From: [REDACTED]
Sent: 07 June 2018 19:54
To: Neil Crowther
Cc: Anita Gardner
Subject: EP/52/18/PL

Objections & Responses: Lime Tree Close:

TITLE: Swept Paths March 2018 SITE: Limetree Close East Preston	Drawing: Vehicle Swept Paths	Autoturn Vehicle Swept Path Analysis & Visibility Data Prepared by Autoturn Specialists in Simulated Vehicle Swept Paths
	Drawing Reference: LT.SWEPT.001	
	Scale: On A2 1:200 / as bar

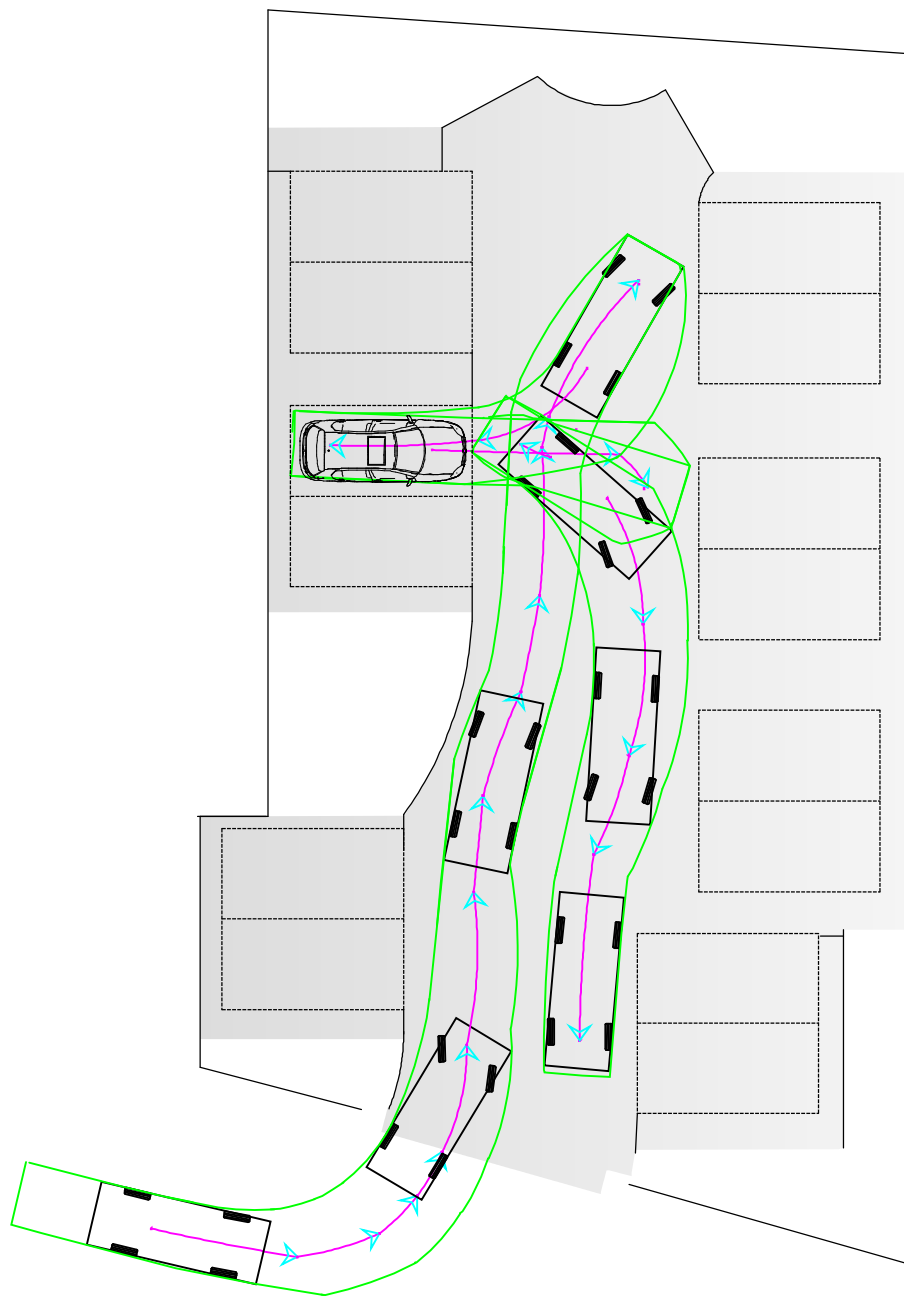
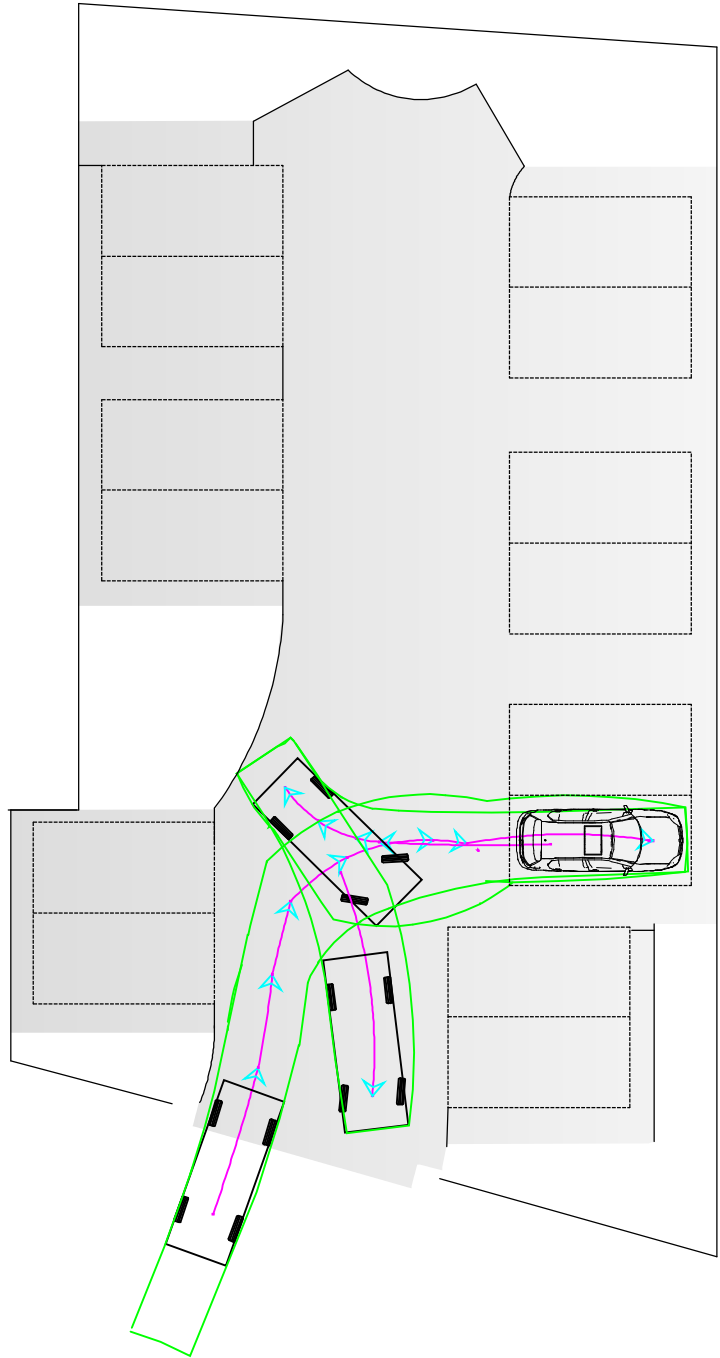
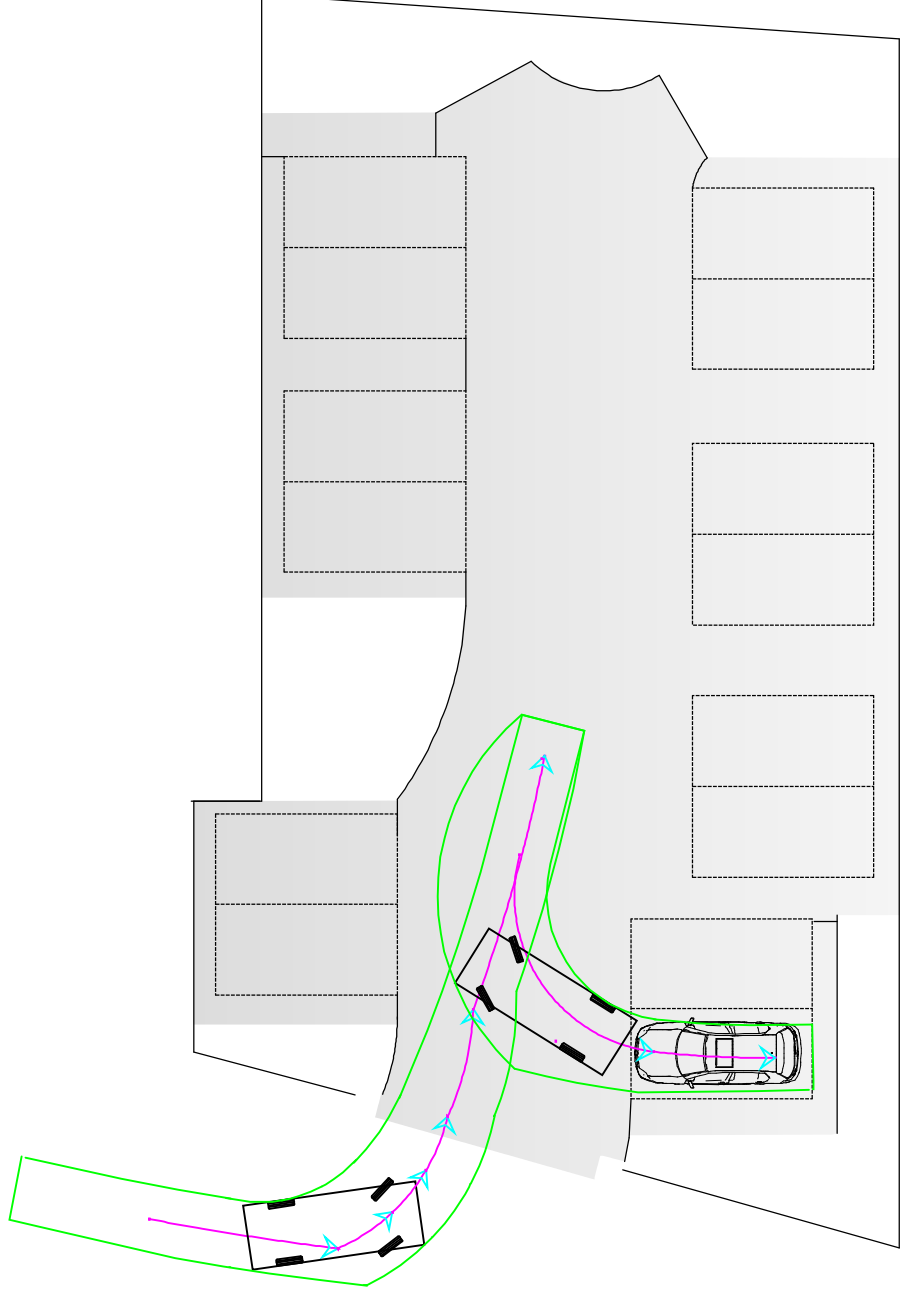
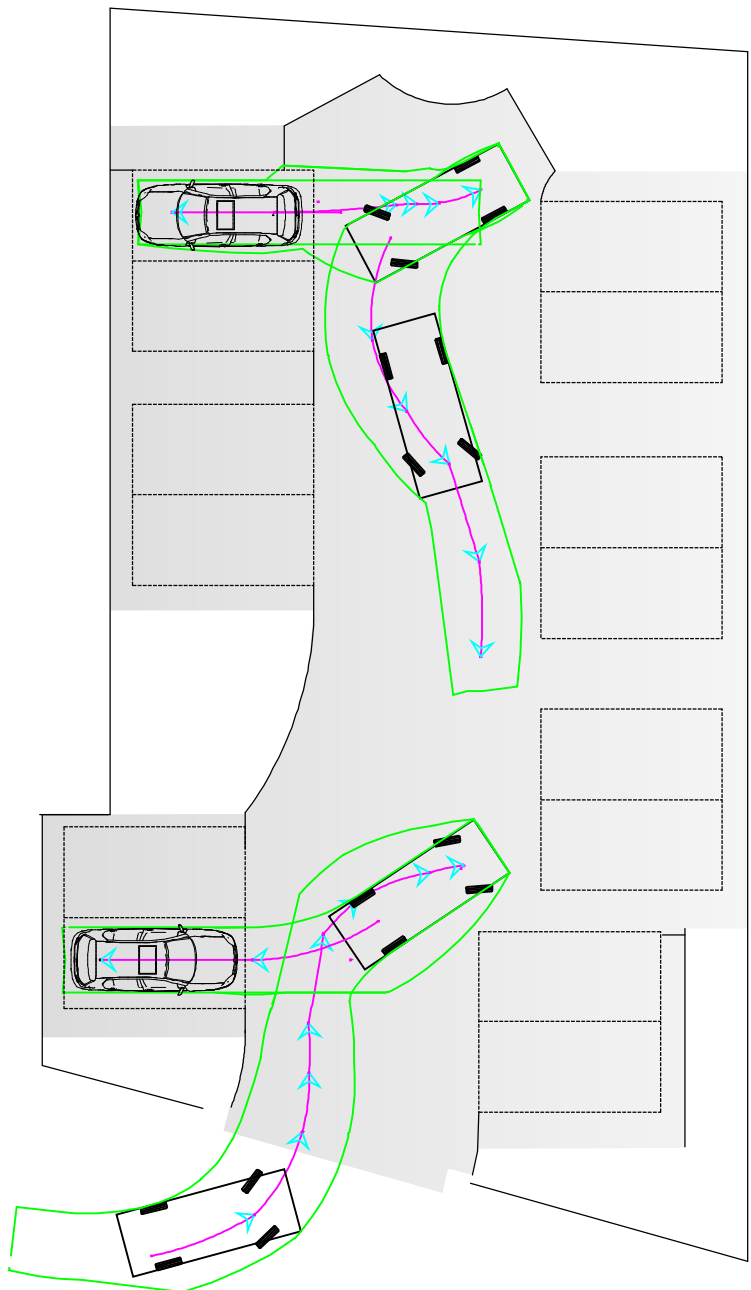
No turning or manoeuvring will be required on Lime Tree Close as sufficient space has been allocated within the site for turning, passing and the space has the capacity to hold several vehicles in transit. The swept path analysis demonstrates this.

The photographs submitted of the large commercial vehicles, in complete contrast to the comments made above, are in fact demonstrating clearly simply how far a large commercial vehicle can actually drive safely in to LTC. Each time the vehicle has to stop exactly where the proposed entrance to the new development is suggested to be as it cannot proceed any further. Not only would this cause obstruction and delay for people arriving and exiting both the proposed new development and LTC. It also would be a safety hazard for the residents of the proposed new development, especially as there is no provision for a footpath.

In response to the last comment of the above paragraph. The plans for the proposed development appears to be minimal parking for the sized houses. This would not allow sufficient space should one or more of the residents have a works van that they bring home, or a larger vehicle than a modern compact car. The planned space certainly does not safely allow for large commercial vehicles to access the proposed development and could be a huge safety hazard to anyone arriving or leaving the proposed development on foot, bicycle or with a pushchair. Resulting in the likelihood that vehicles would drive in to LTC. Abandon their vehicle while they make a delivery or attend an appointment in the proposed new development. This has a direct negative impact on the residents of LTC.
